# MDT-PUDSP21010-R1-FDR.pdf Markup Summary

Add text:  
PCD Filing No.:  
PUDSP2110

DR-1
Sheet 1 of 3

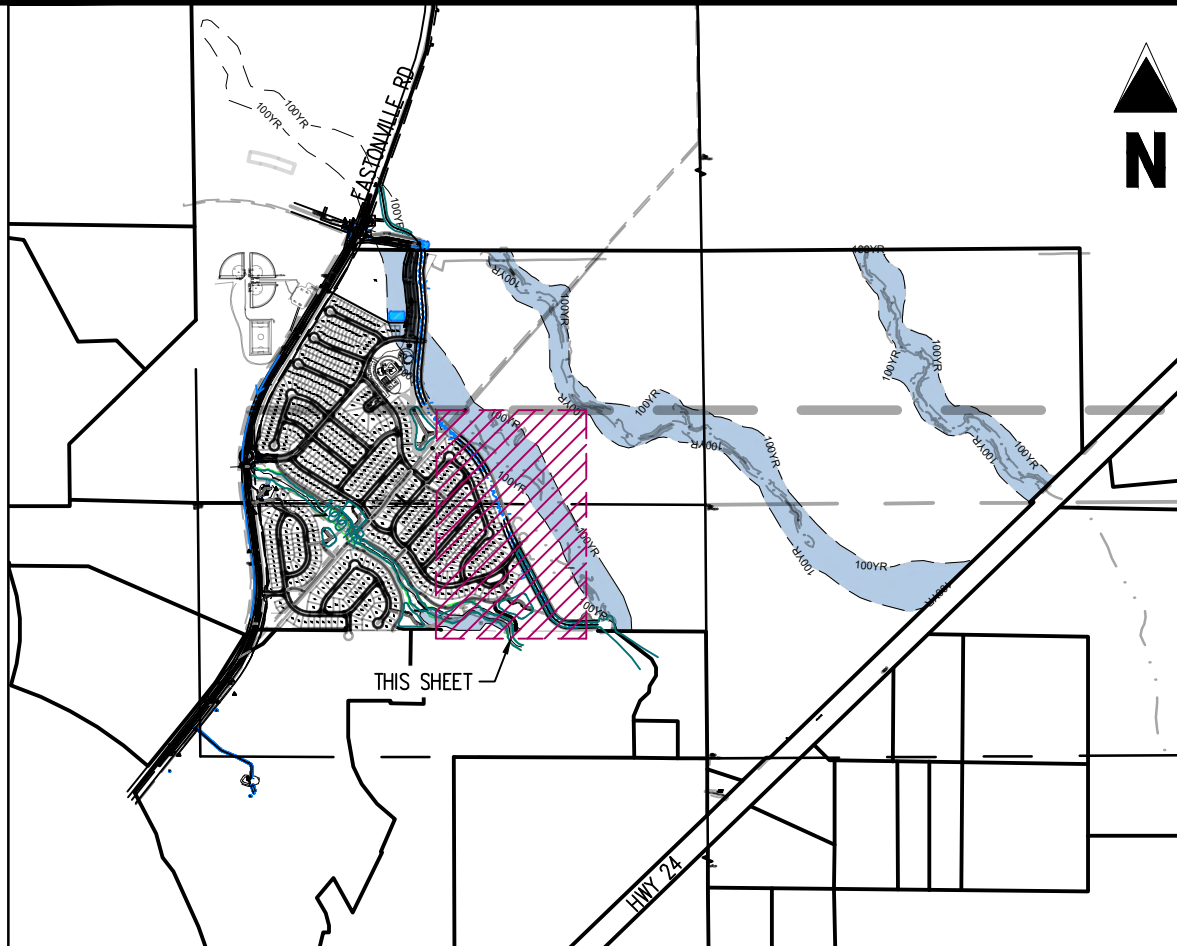
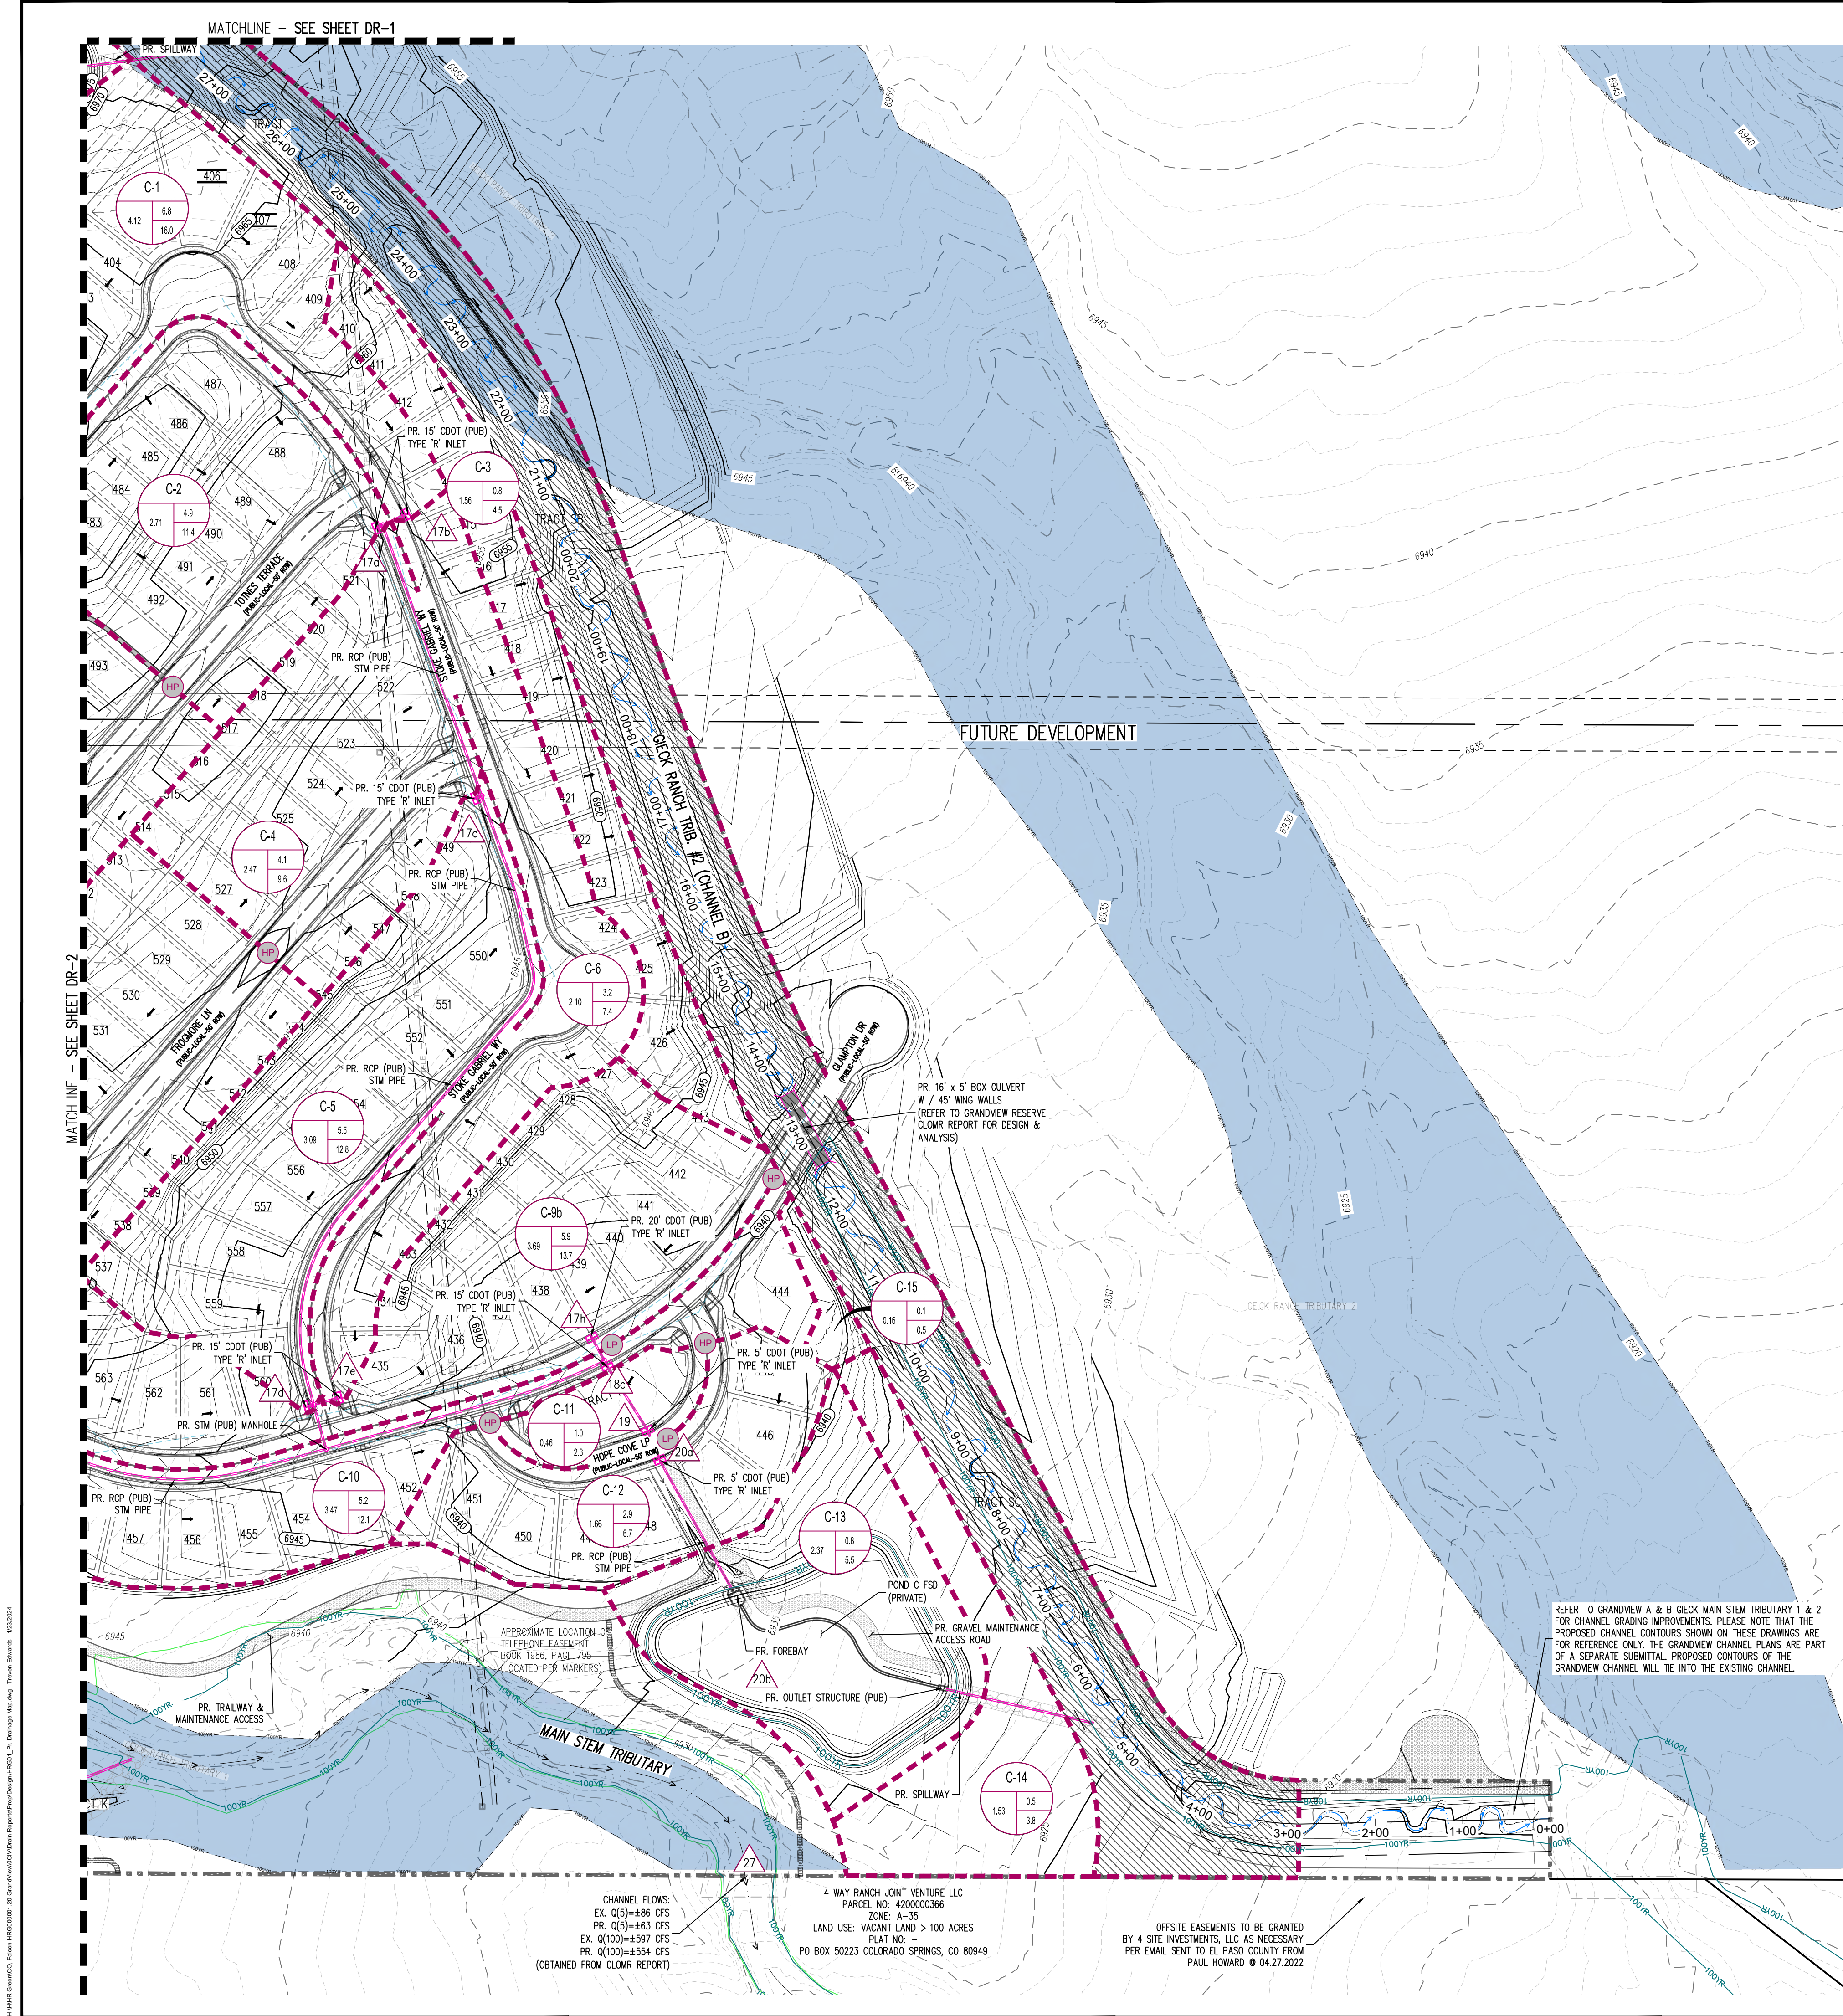
Address existing culvert and offsite flows

crossing Eastonville or driveway?

Show and label existing driveway

Provide existing and proposed contours around the intersections to show topography and how drainage will be diverted, flows captured.

Label Lot/Tract

Provide a tract for the drainage facilities and access
